Memorandum

Date: September 6, 2013

Re: **September 10th Planning Board Workshop**
 Level III Site Plan and Subdivision:
 6 unit condominium, 133 York Street
 133 York, LLC (Joe Flynn), Applicant

PLAN 3

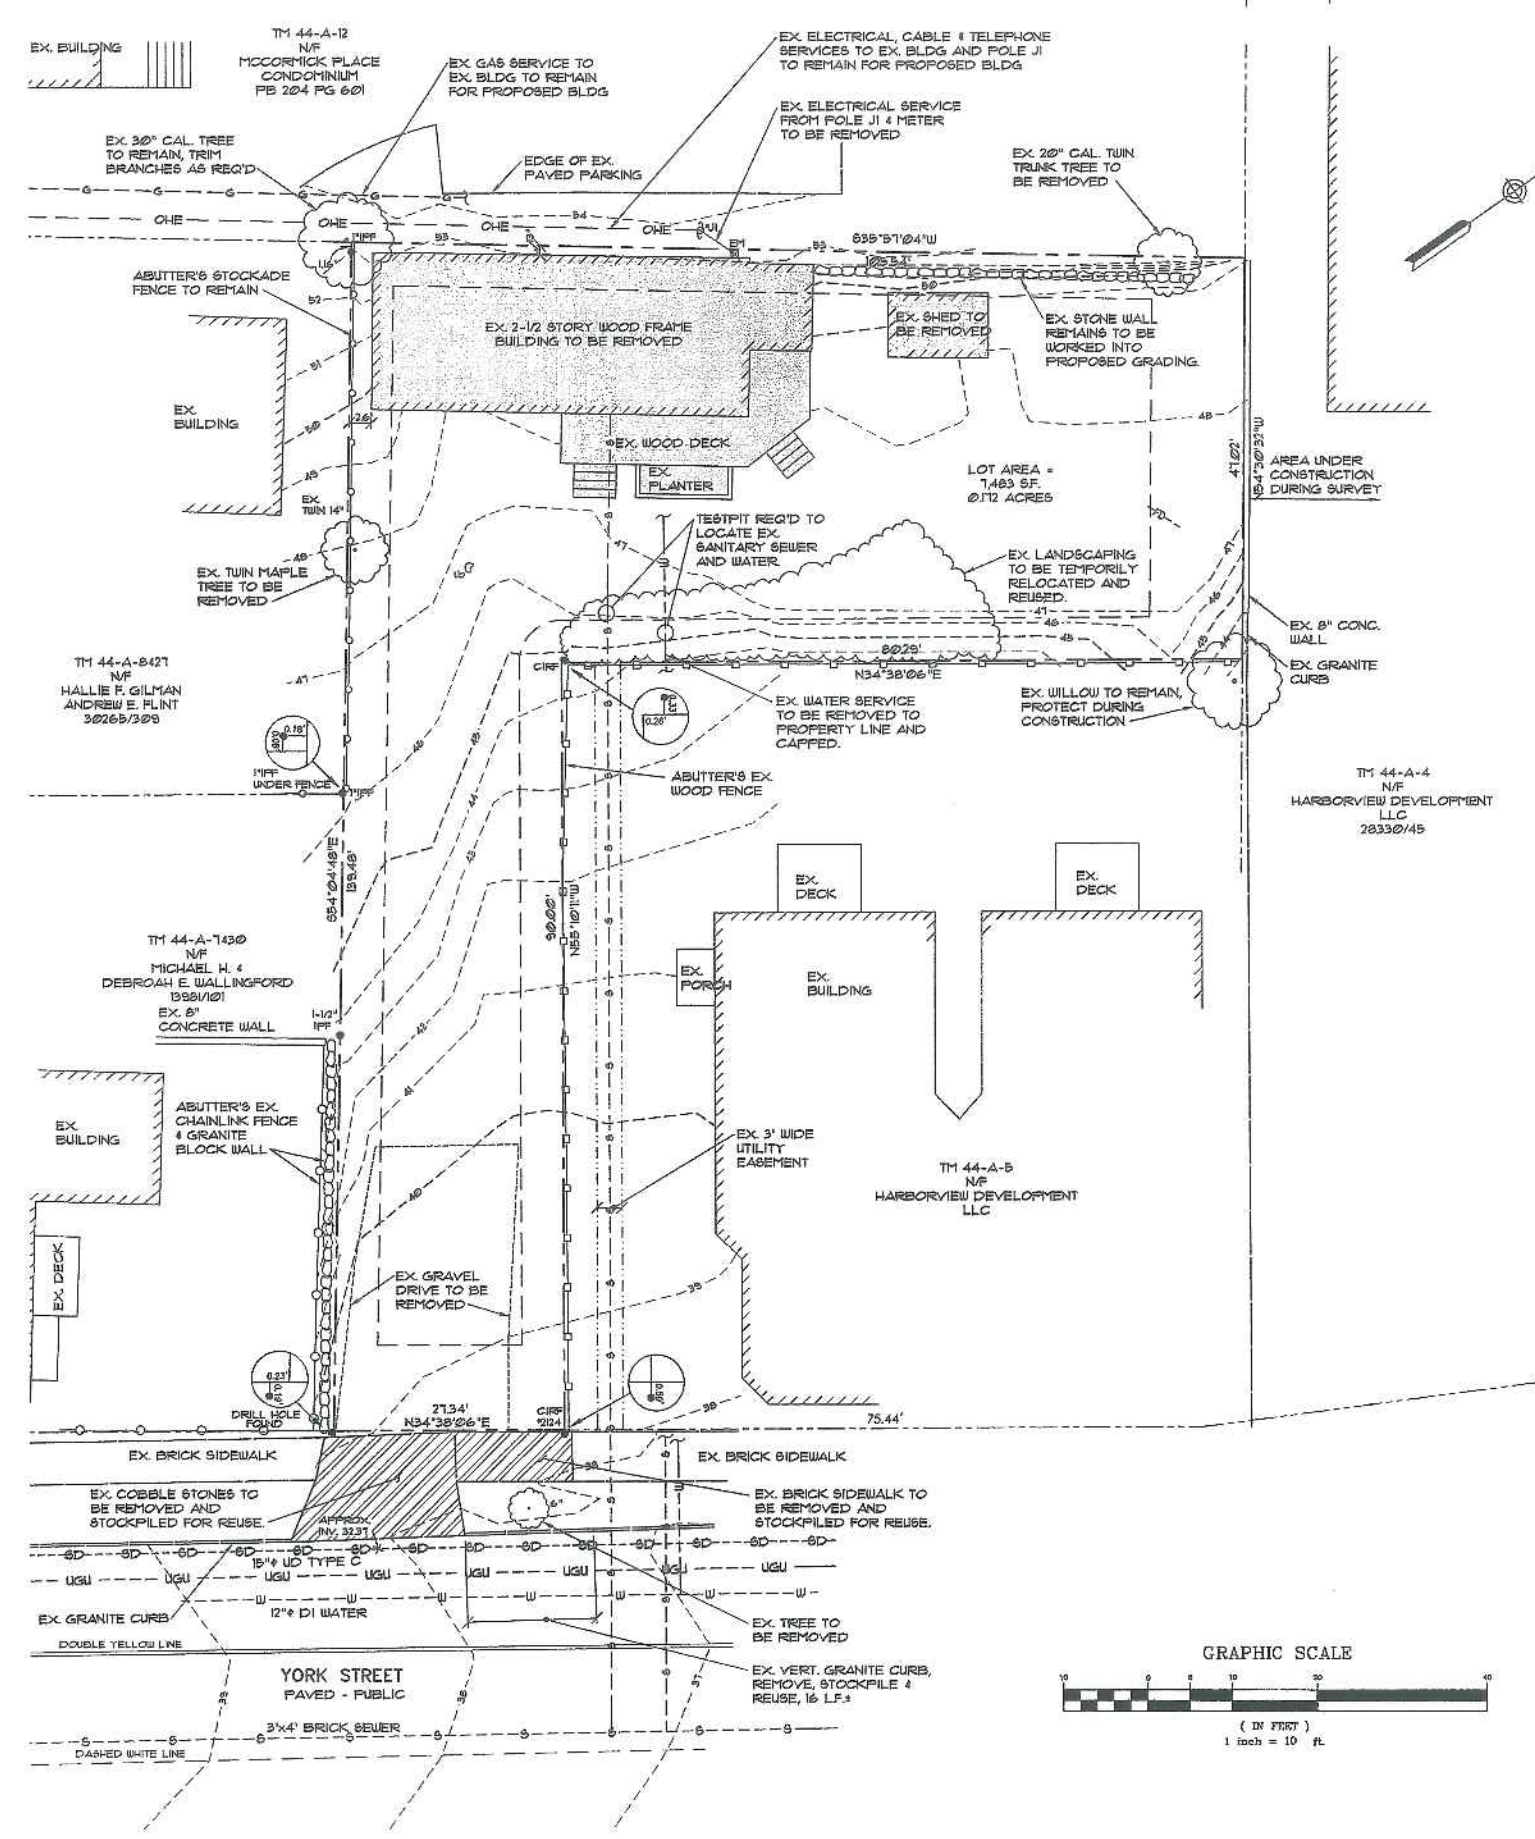
The Demolition Plan (Plan 3) indicates the removal of 2 large trees on site and the smaller vegetation along the south boundary. The Landscaping Plan (Plan 5) proposes the planting of 7 trees: 4 at the eastern side of the building and 3 along the access drive. In a meeting with neighbors, attended by the City Arborist, nearby residents requested that the twin trunk 30 in tree in the NE corner (see Attachment 8) be retained but it appears this would not be possible given the proposed building location. Two replacement trees are proposed as allowed by the City Ordinance waiver provisions.

The City Arborist, Jeff Tarling, has reviewed the proposals and met with the applicant and neighbors on site. In addition to some recommendations regarding the species of new trees, he is concerned that measures are in place to save the two remaining large trees (Attachment 8).

PLAN 4

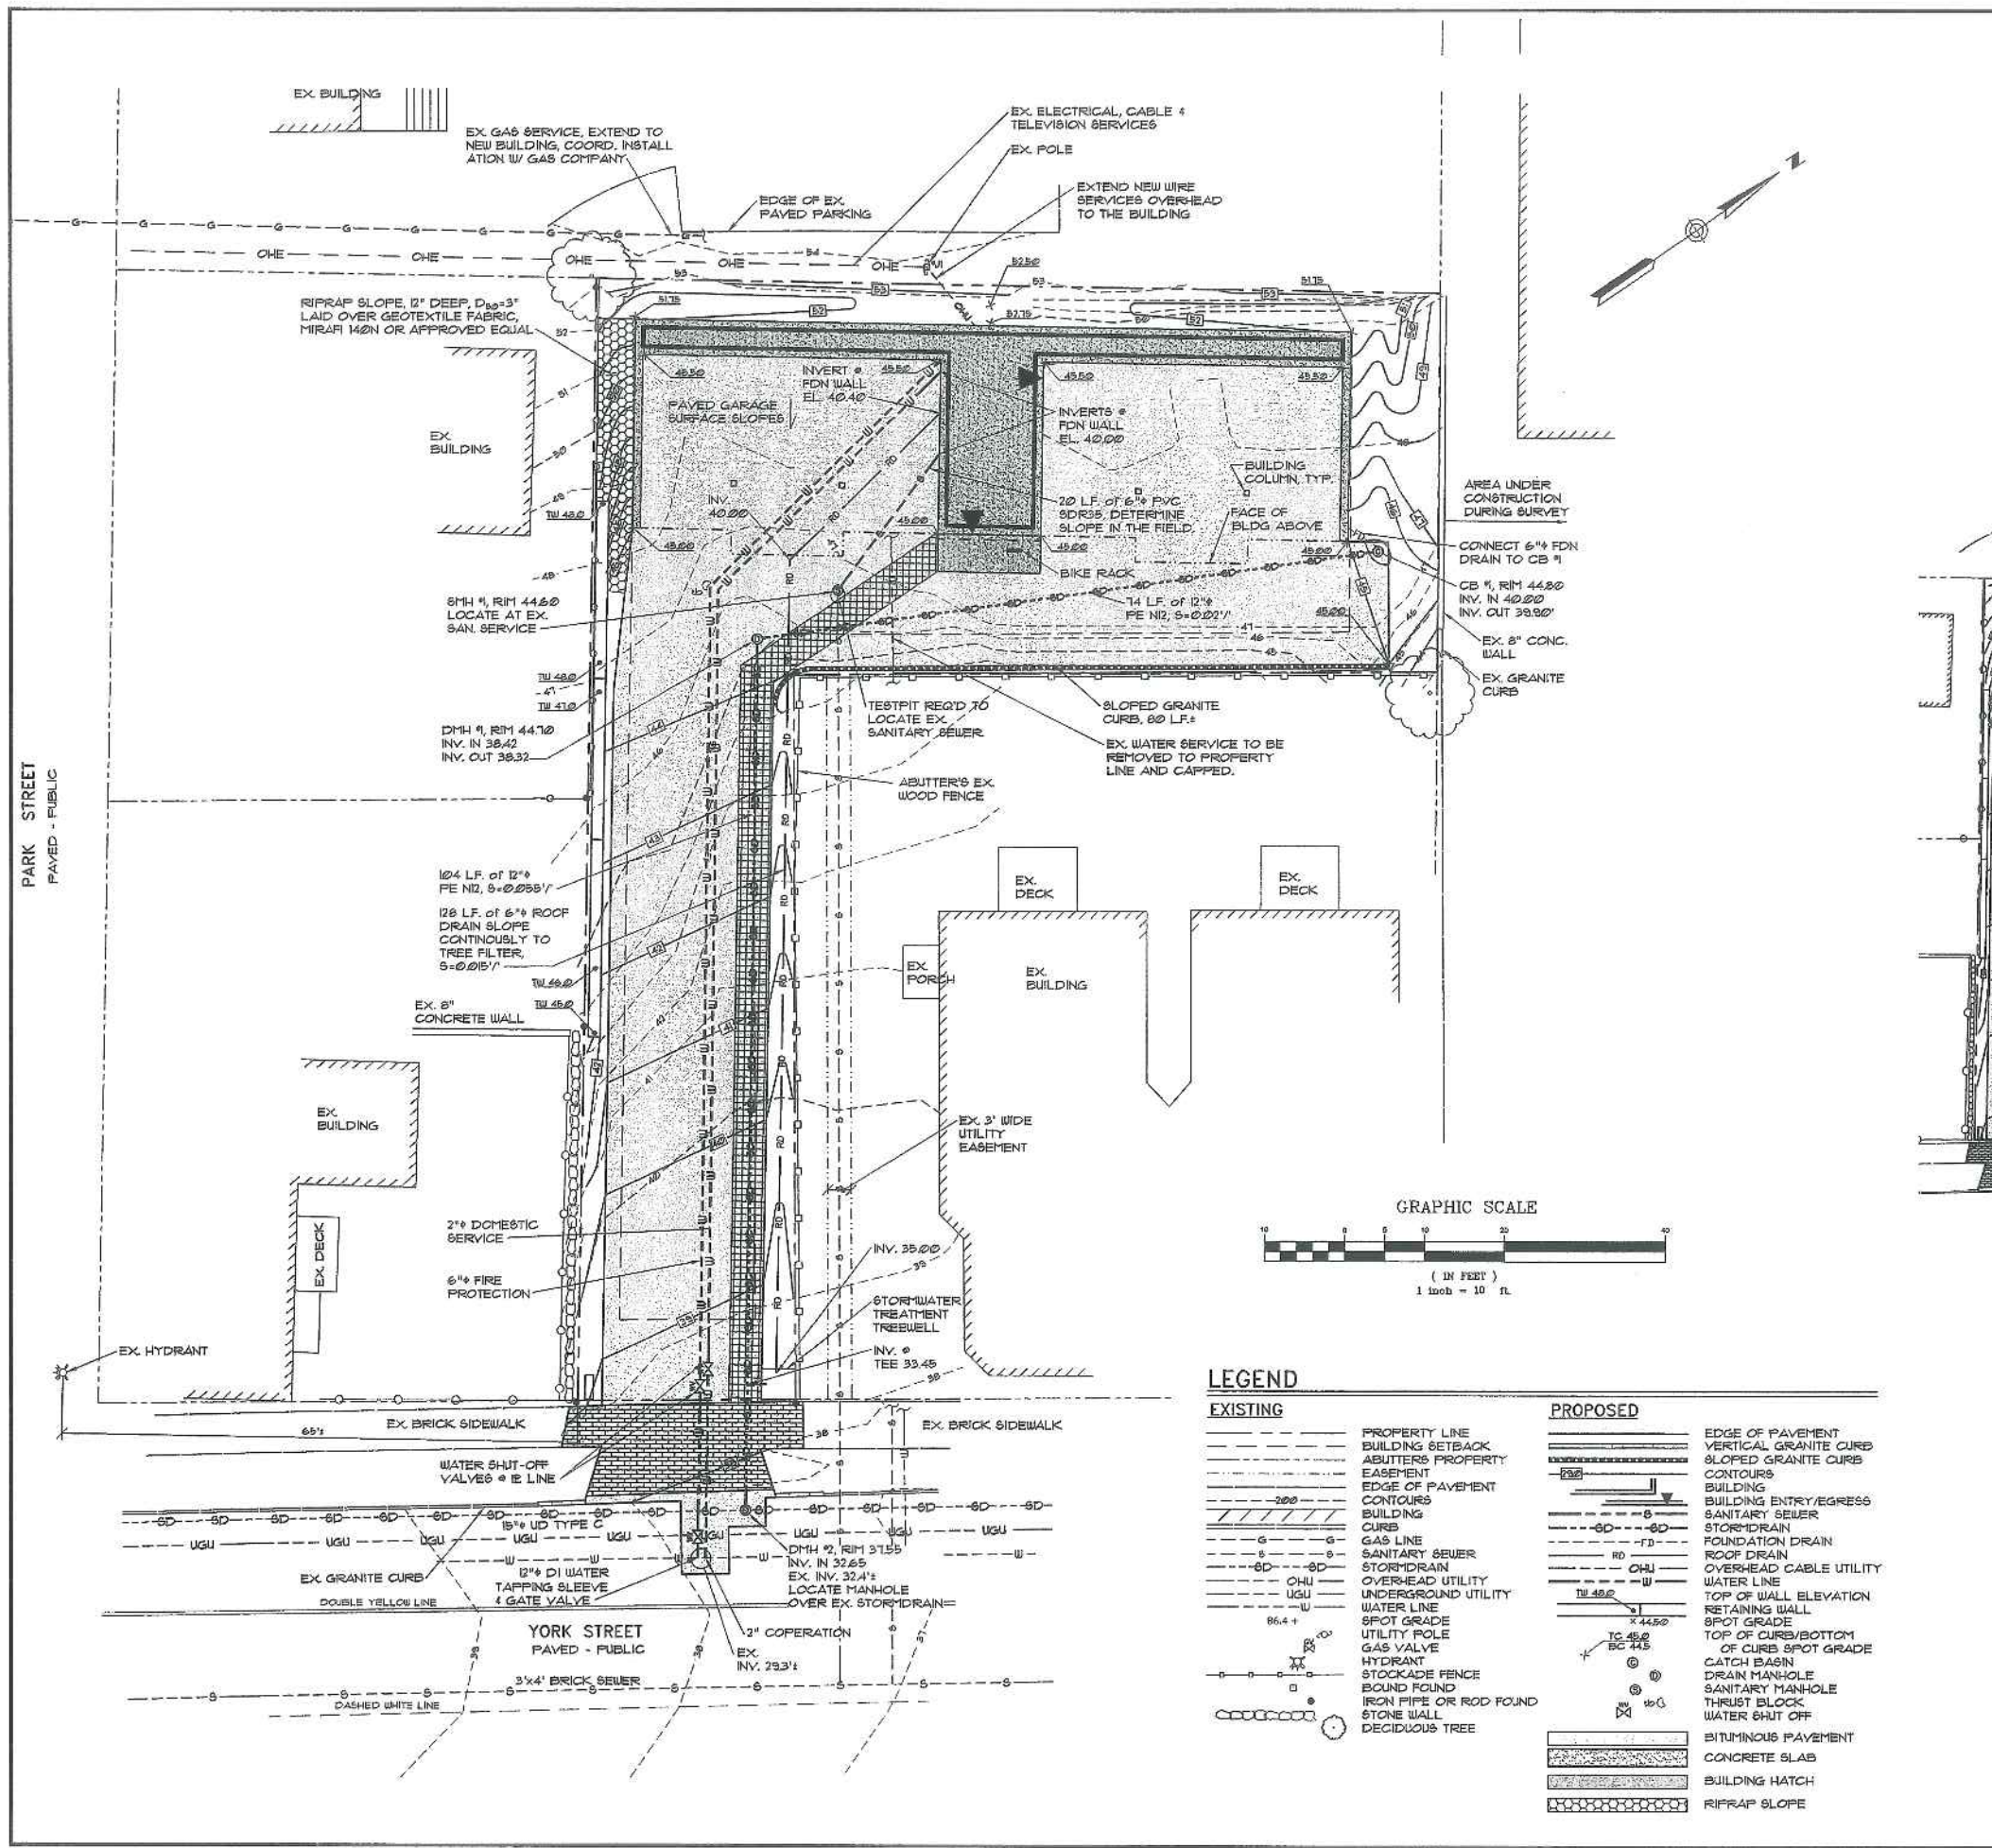
The water and sewer service come from York Street and the gas, electric and cable will be from Park Street. The “Grading and Utility Plan” ([Plan 4](#)) has recently been revised to show the electric line as overhead to address reflect the Engineering comments about inconsistency ([Attachment 3](#)). The original submission showed the connection as being underground and that proposal should be re-instated to comply with the Subdivision ordinance which requires all utilities to be underground. The Engineering Reviewers ([Attachments 3 and 6](#)) point out that an easement from the McCormick Place condominiums appears to be necessary to achieve this connection, and may also be necessary regarding the gas and cable feed.

PLAN 5

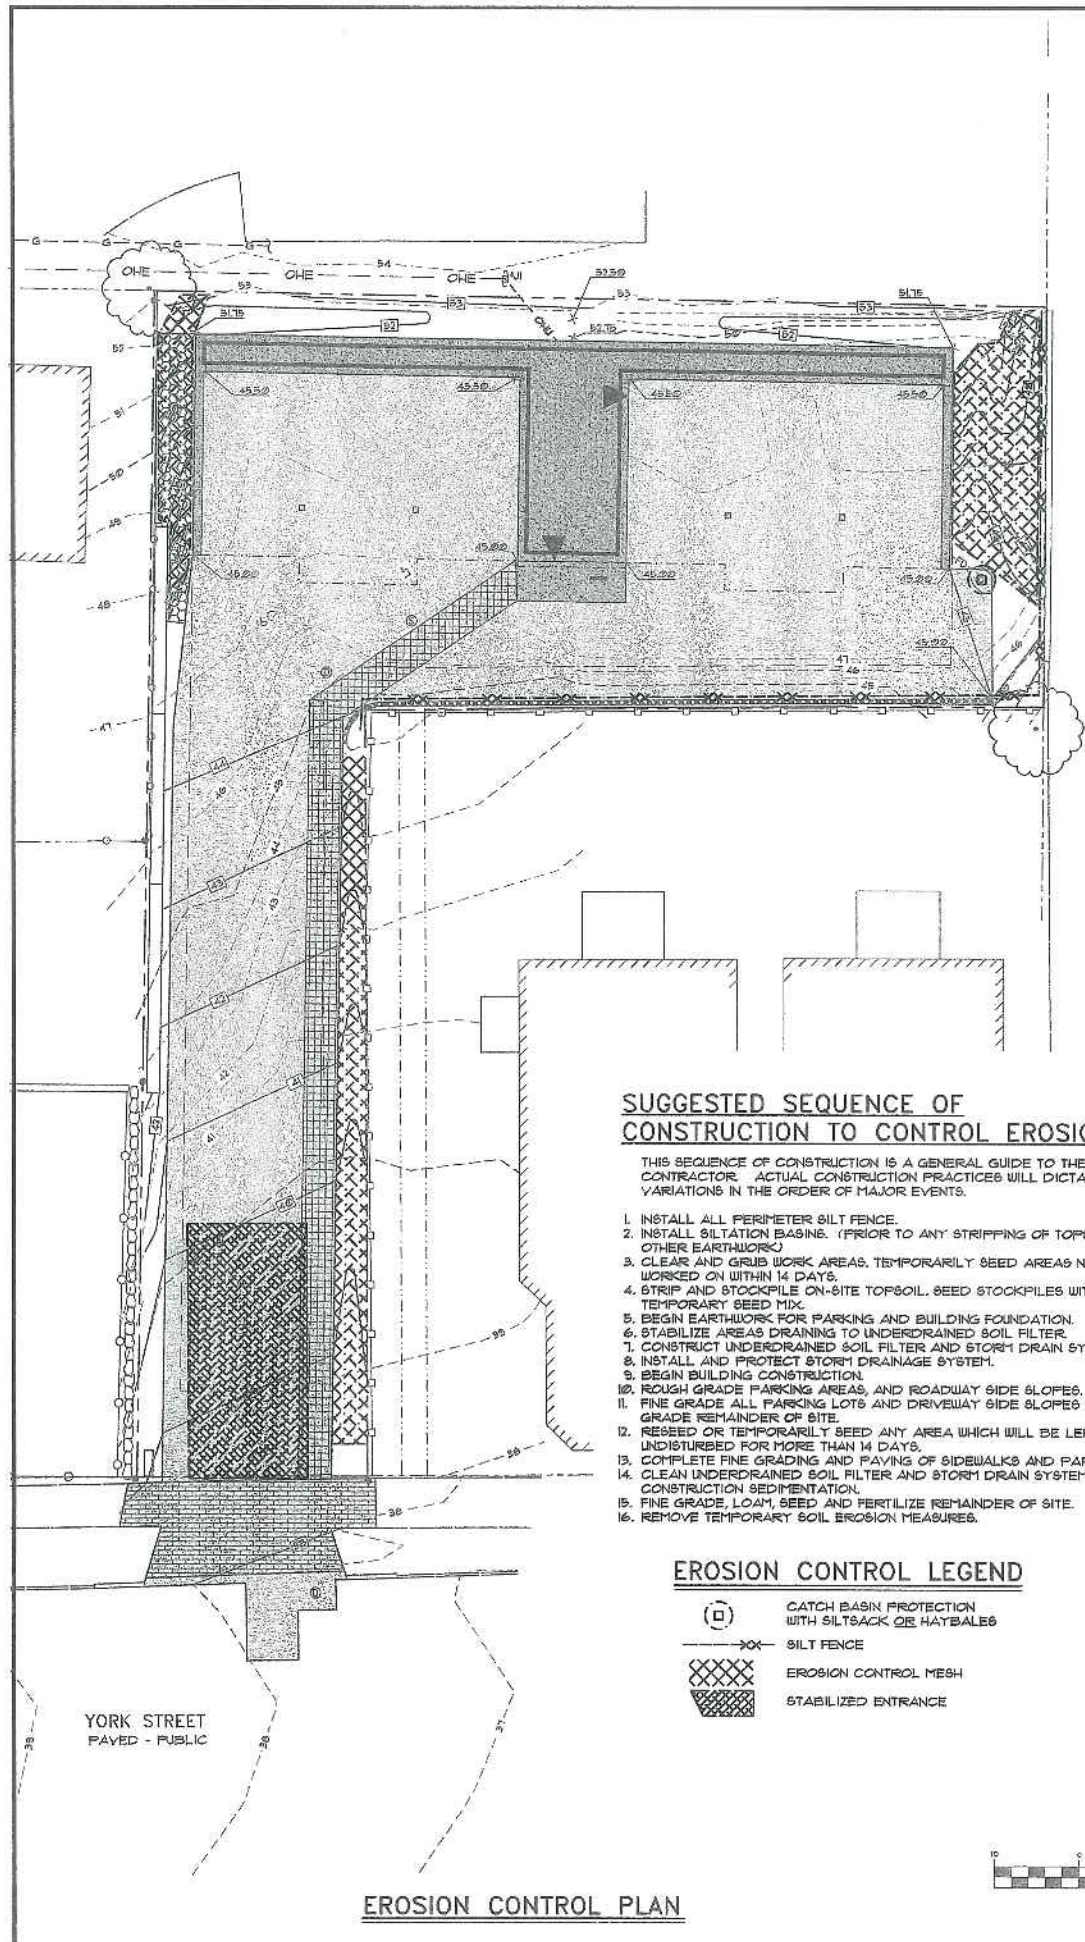
Small scale landscaping is proposed along the east and north sides of the new building and three trees are proposed along the new driveway (Plan 5).

An Erosion Control Plan has been submitted (Plan 5) and is acceptable (Attachment 3).

1
A-202
NORTH ELEVATION
SCALE: 1/4"=1'-0"

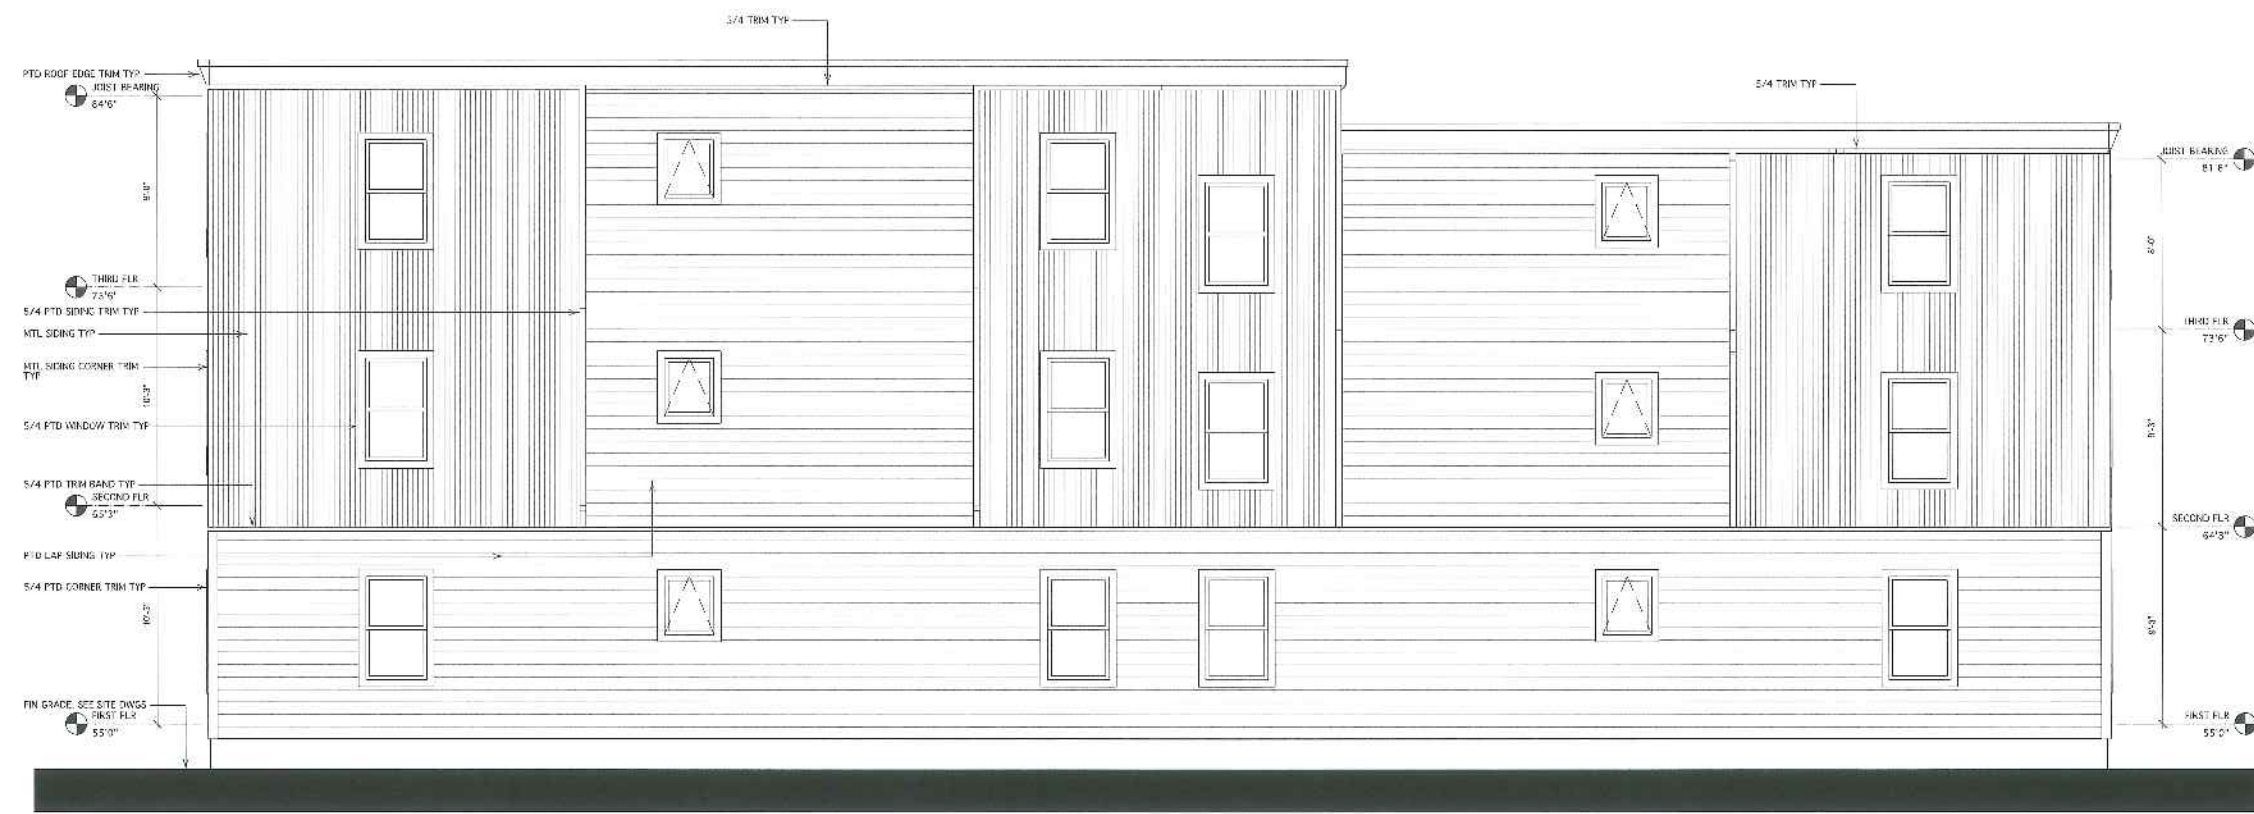
The building height is being met (under 45'). However, the dimensions are being shown to the joist bering and not to the top of the joist as required by definition. I would like to see revised drawing that show the building height from grade (or average grade) to the top of the roof beam.
